Appeal Decision

Appeal Ref: APP/R5510/D/25/3365494

28 Hillingdon Hill, Uxbridge, Hillingdon UB10 0JB

- The appeal is made under section 78 of the Town and Country Planning Act 1990 (as amended) against a refusal to grant planning permission.
- The appeal is made by Mr Michael Brazier against the decision of the Council of the London Borough of Hillingdon.
- The application Ref is 79342/APP/2025/613.
- The development proposed is described as: 'we would like to drop our front garden to accommodate parking our car.'

Drawing name:
Existing & Proposed Plan

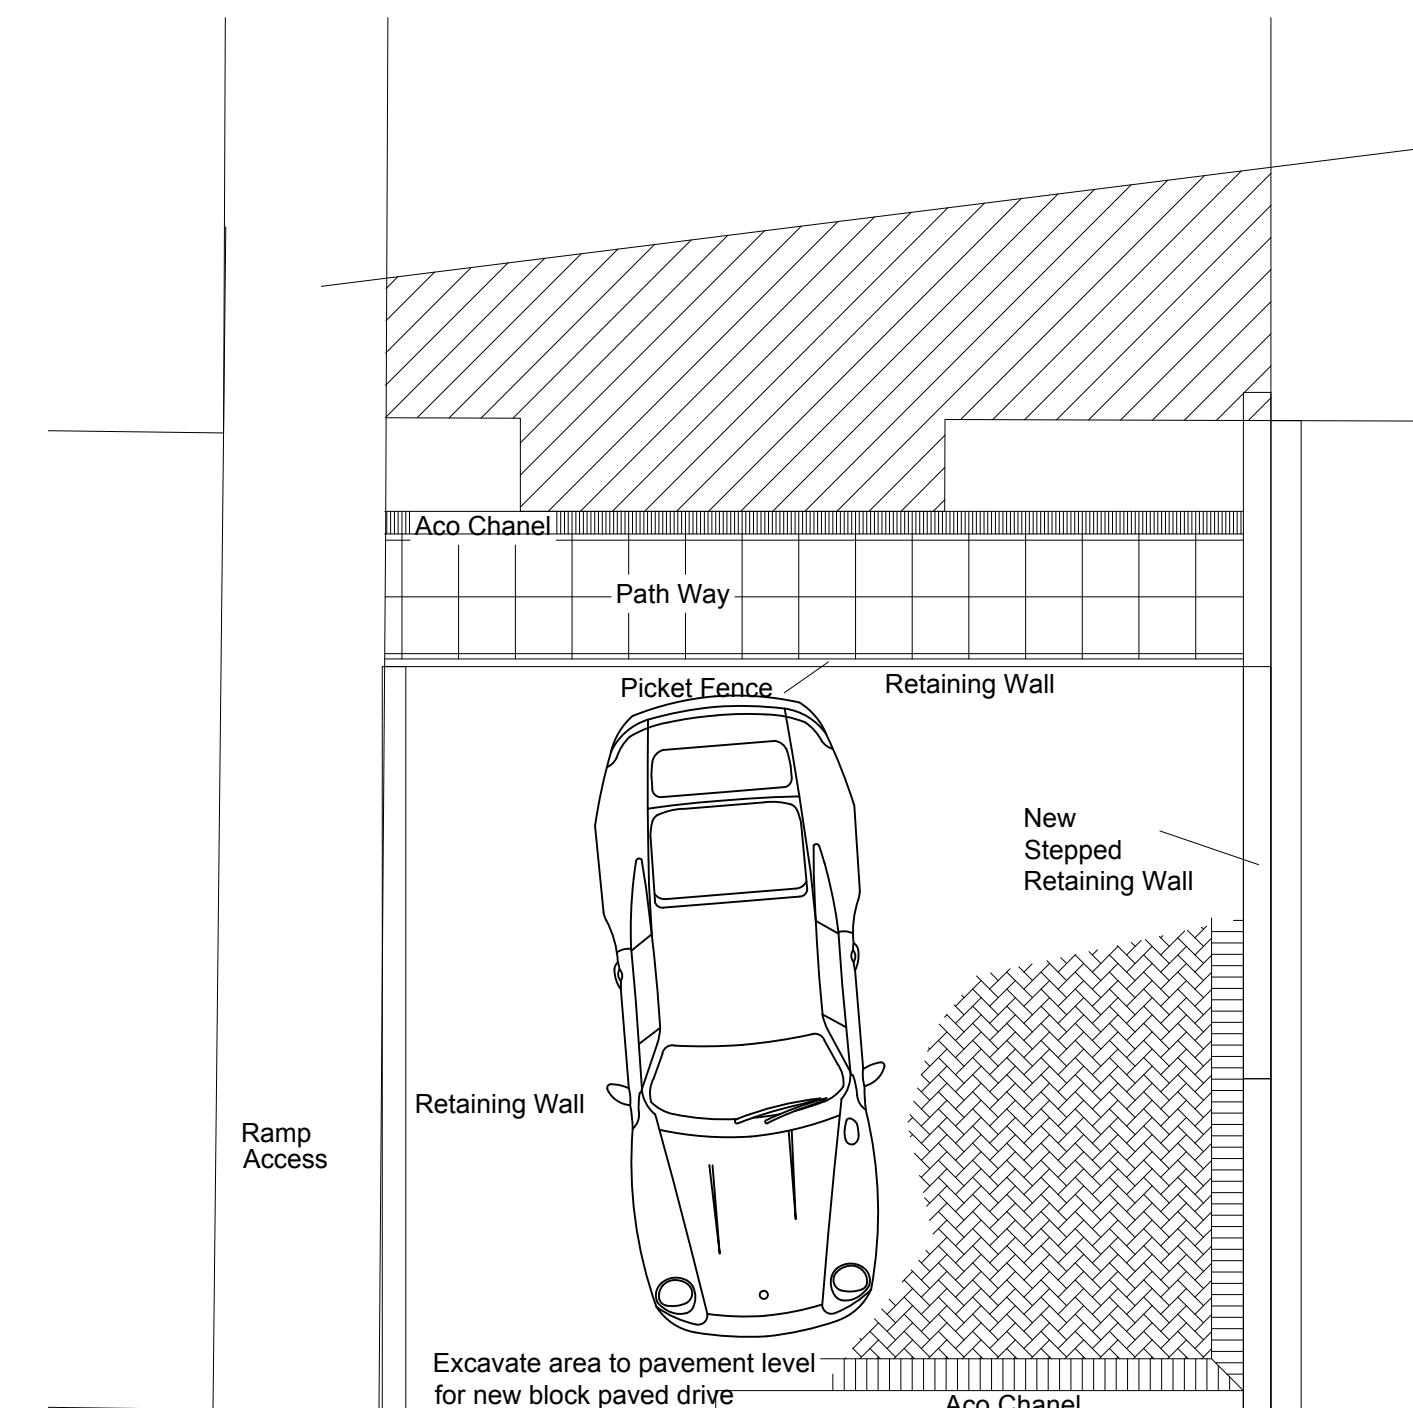
5. The appeal site comprises a two-storey semi-detached house located on the southern side of Hillingdon Hill. The dual carriageway at this location is a classified road, subject to a 40mph speed limit. There is a footway in front of the properties on Hillingdon Hill at this location, as well as controlled parking bays within the carriageway.
6. The details before me indicate the formation of a driveway/parking space within the small front garden and the formation of a vehicle crossover, amongst other things. The amount of space for vehicle parking at the proposed dwelling would be limited and would not allow for vehicles to enter and exit in a forward gear. Given the limited space to manoeuvre, it would require the occupiers to reverse into or out of

the parking area, across the footway and onto Hillingdon Road. Although a snapshot in time, I observed during my visit that Hillingdon Road is heavily trafficked and vehicle speeds are relatively high. This chimes with the description of the road by the Highway Authority and the appellant's view that 'cars come very fast.'

7. Vehicles reversing into the proposed parking area would be forced to wait in the carriageway until the road was sufficiently clear to make the manoeuvre, particularly when the car parking bays are occupied. Approaching vehicles may not anticipate stationary vehicles in the carriageway and this could lead to an increased potential for collisions.

8. Vehicles parked in the controlled parking bays, which were mostly occupied during my visit, would also adversely affect visibility sight lines of oncoming traffic, particularly in the instances where a vehicle would reverse onto Hillingdon Road. I accept that the parking bays would not always be occupied. Nonetheless at the times that they are, there would be an increased risk of conflict between all users, which would increase highway danger.

9. Furthermore, given the volume of traffic using Hillingdon Road, there would be the likelihood that the occupants would be required to wait for some time when exiting the appeal site in a vehicle, blocking the footway, and forcing pedestrians to wait or manoeuvre into the highway to get past. This would be particularly problematic for people with mobility or visual impairments and parents with small children. It would increase the likelihood of bringing pedestrians into conflict with moving vehicles and thus hazardous highway conditions.

10. As such, these manoeuvres would be dangerous due to the competing vehicular and pedestrian traffic, the speed and volume of traffic at this location, the restricted visibility when reversing and the attention required to navigate all of these competing pressures at this location. Although I note that the appellant feels unsafe accessing their car on the road, I am not satisfied that the proposal would improve highway safety for either pedestrians or drivers including the appellant.
